DECISION DELEGATED TO HEAD OF PLANNING

Application No: H14-0224-24 **Applicant:** Cecil Francis Ltd

Proposal: Details of surface water disposal, external materials, external doors/door frames, window frames and gas/electricity boxes (Conditions 9, 14, 15, 16 and 19 of H14-0706-22)

Location: Cecil Francis Ltd Bear Lane Pinchbeck

**Plots 1, 2 and 3
Window & door jamb, head and
sill details**

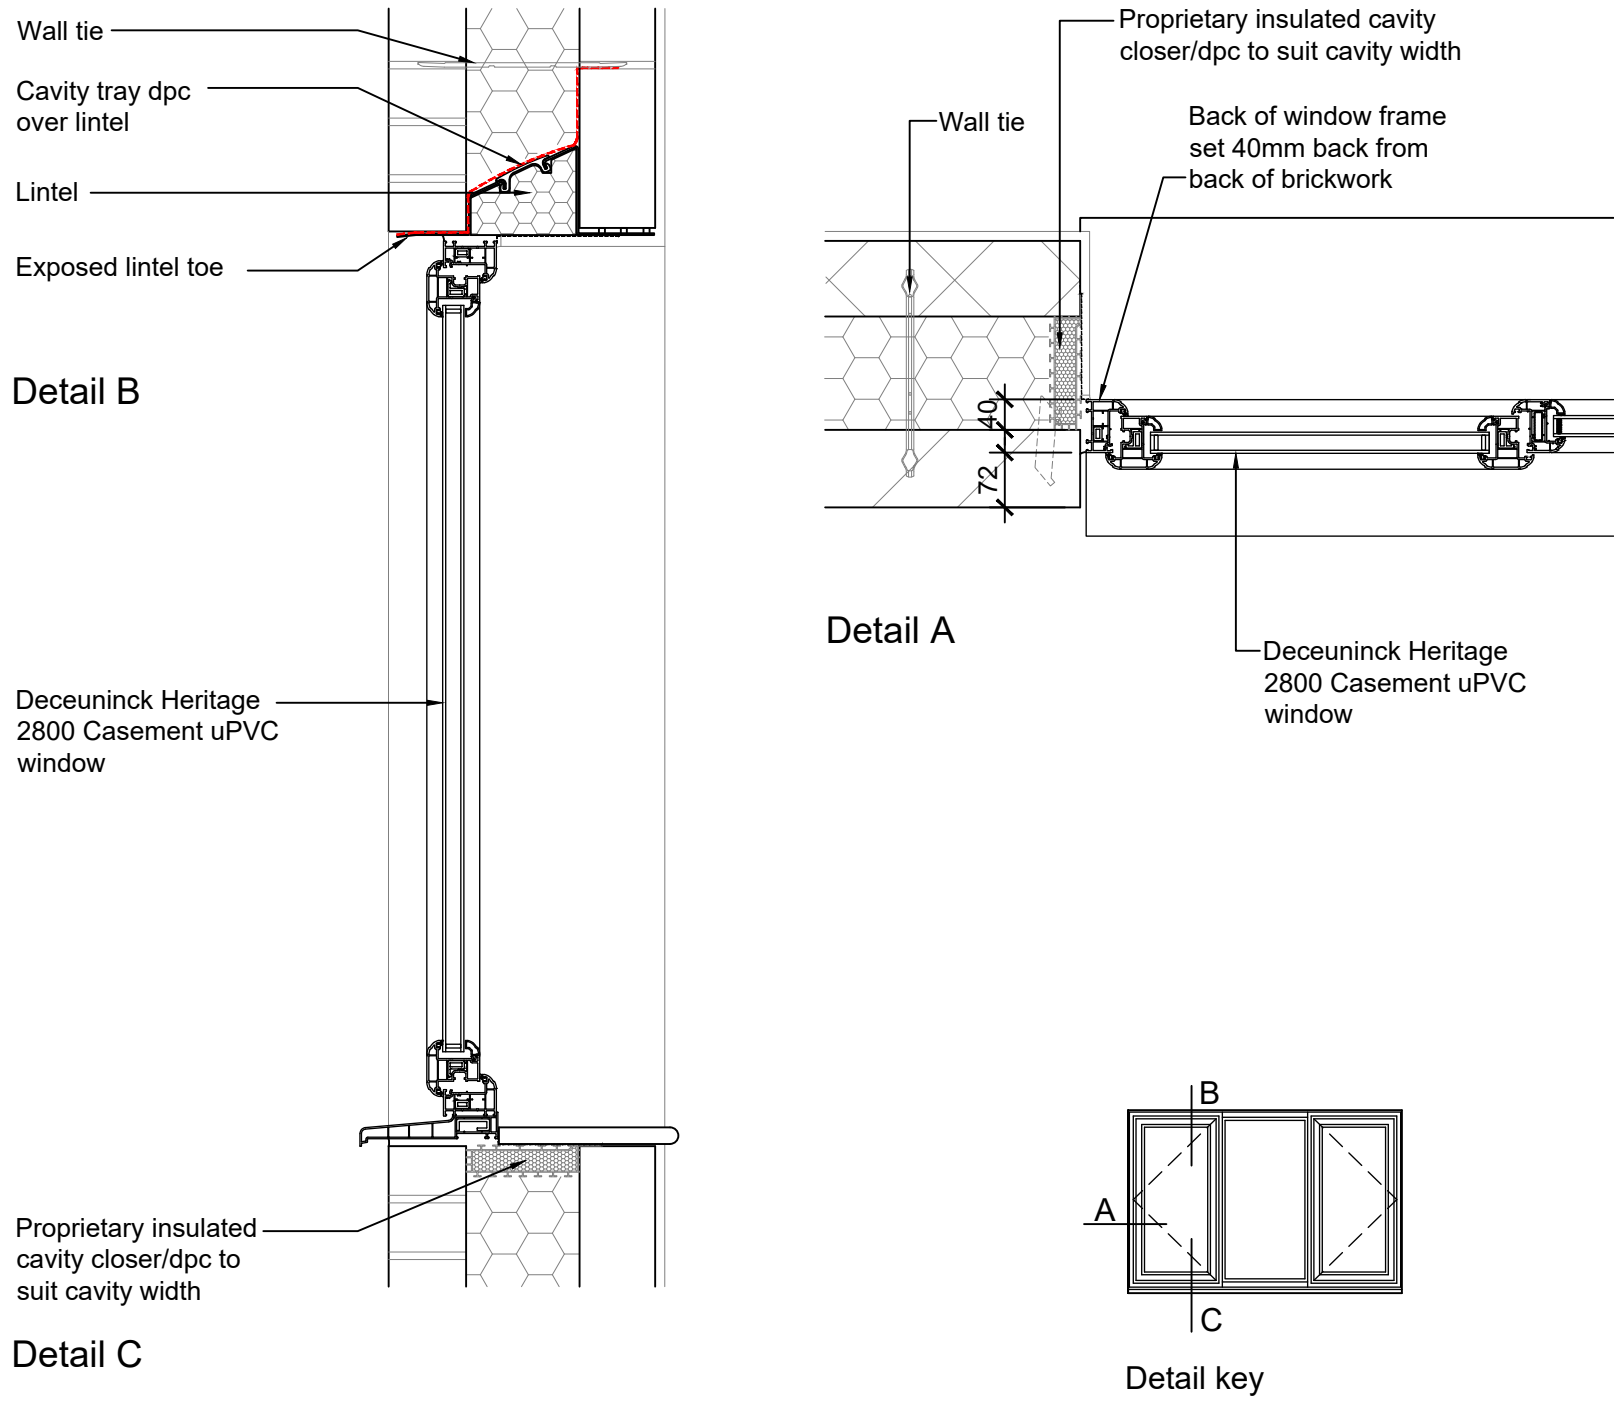
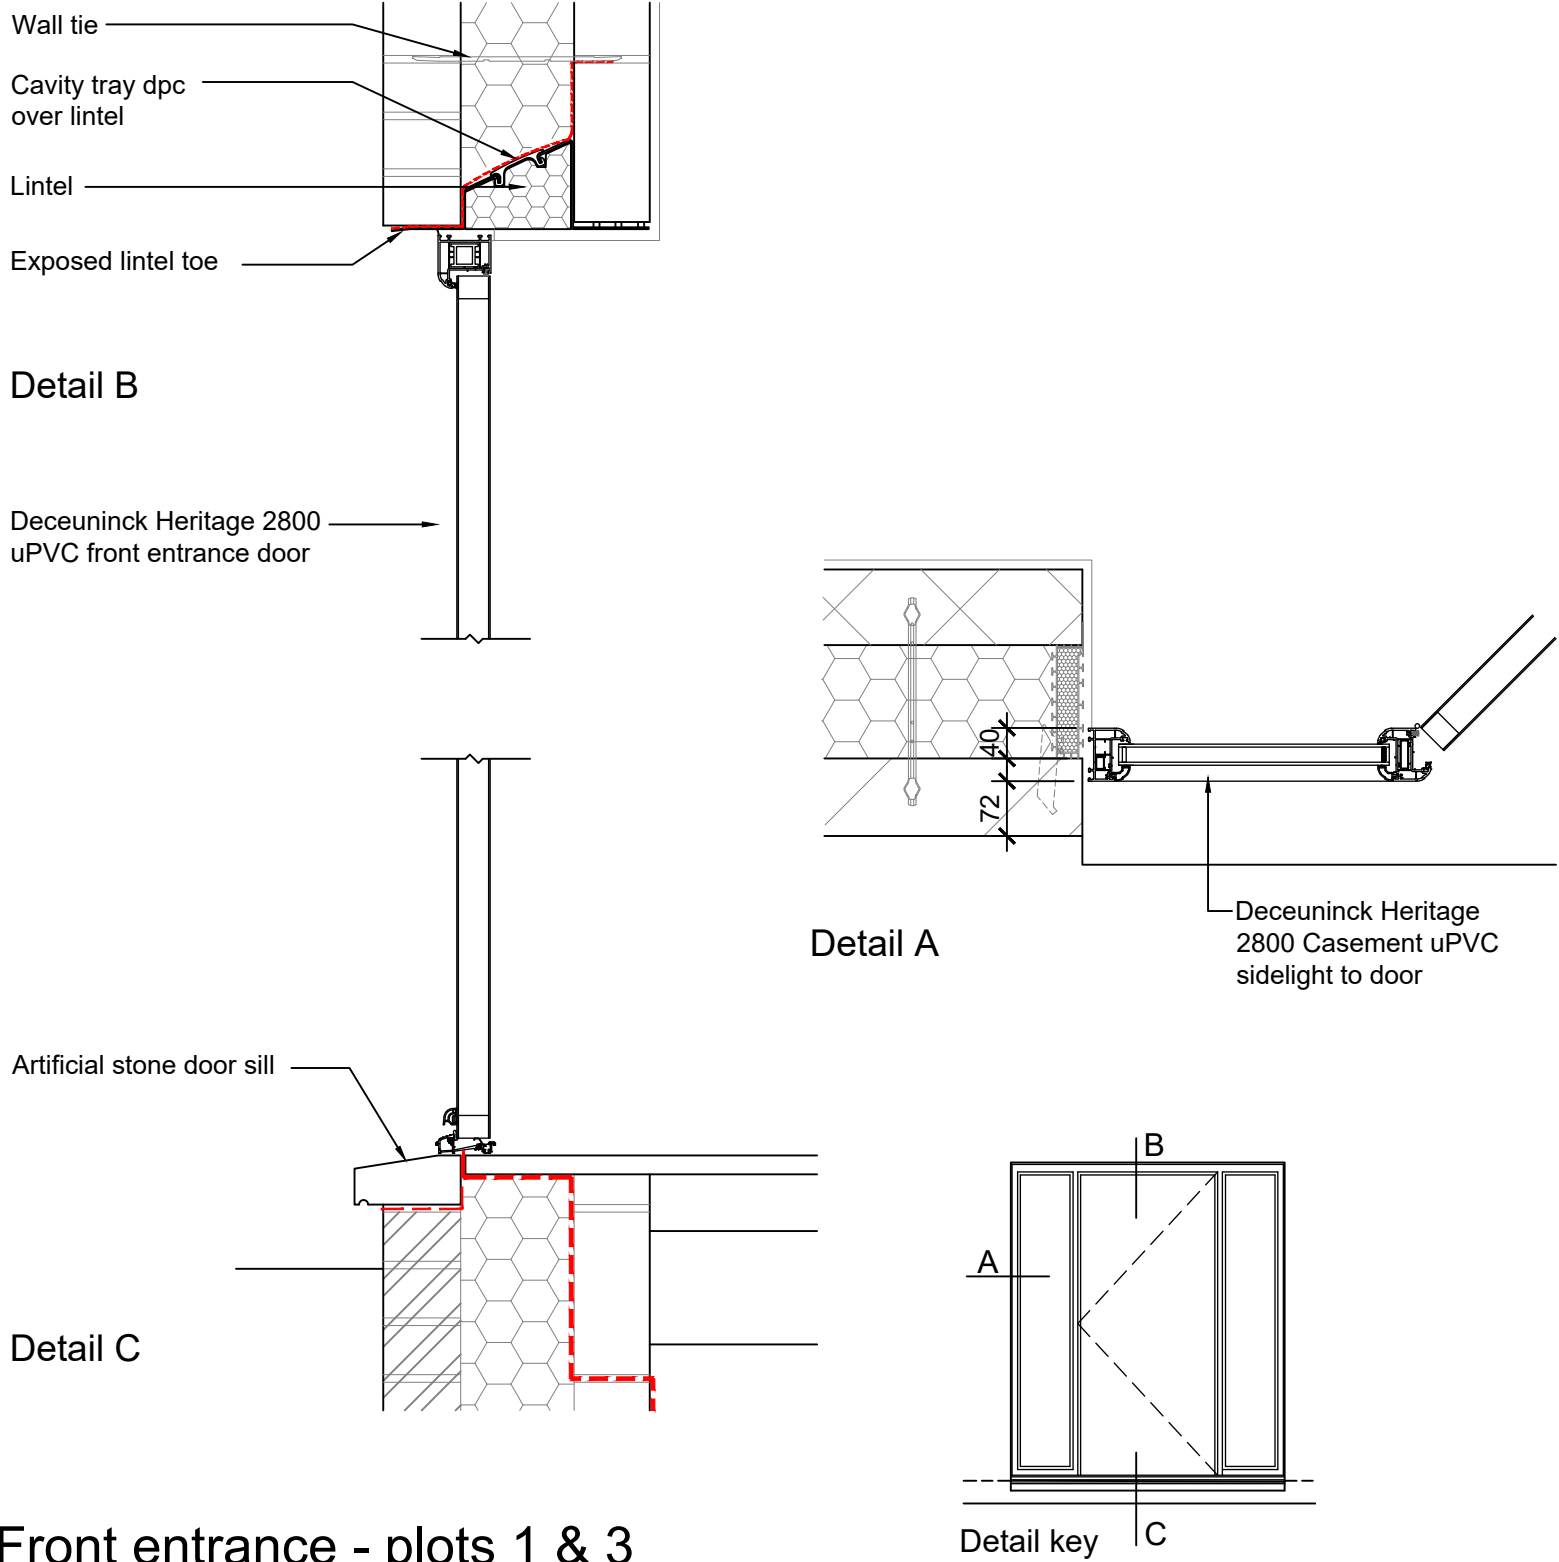
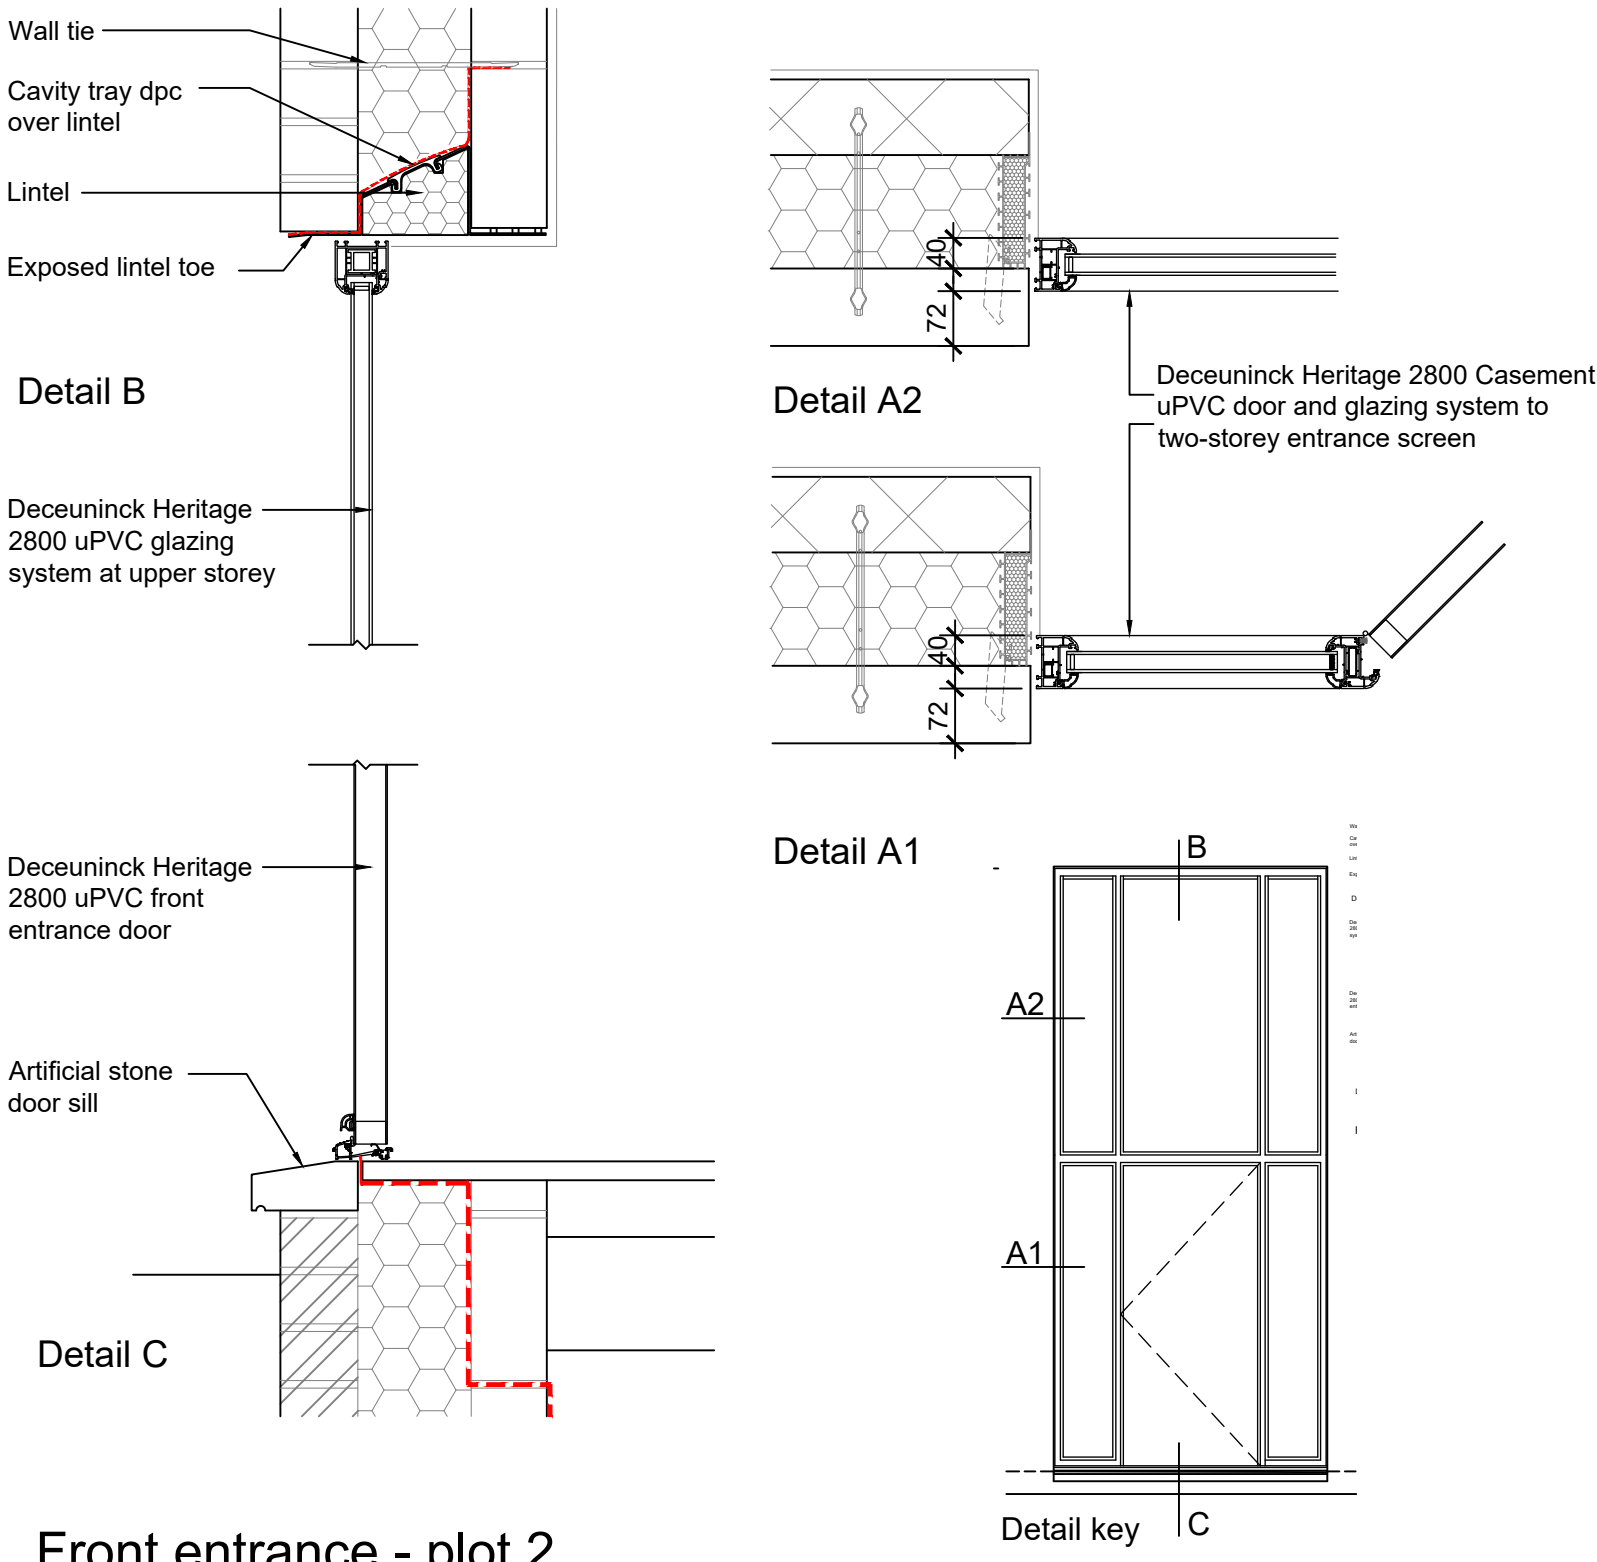
The external entrance doors are to be Deceuninck Heritage 2800 uPVC, anthracite grey. The external bi-fold doors are Deceuninck Slider 24 uPVC, anthracite grey. The garage doors are Aluminium up and over doors, anthracite grey. Window and door jamb, head and sill details are also provided.

Windows are to be Deceuninck Heritage 2800 uPVC, anthracite grey. Window and door jamb, head and sill details are also provided.

The details are considered satisfactory and condition 15 can be discharged.

It is considered that the details are satisfactory and condition 16 can be discharged.
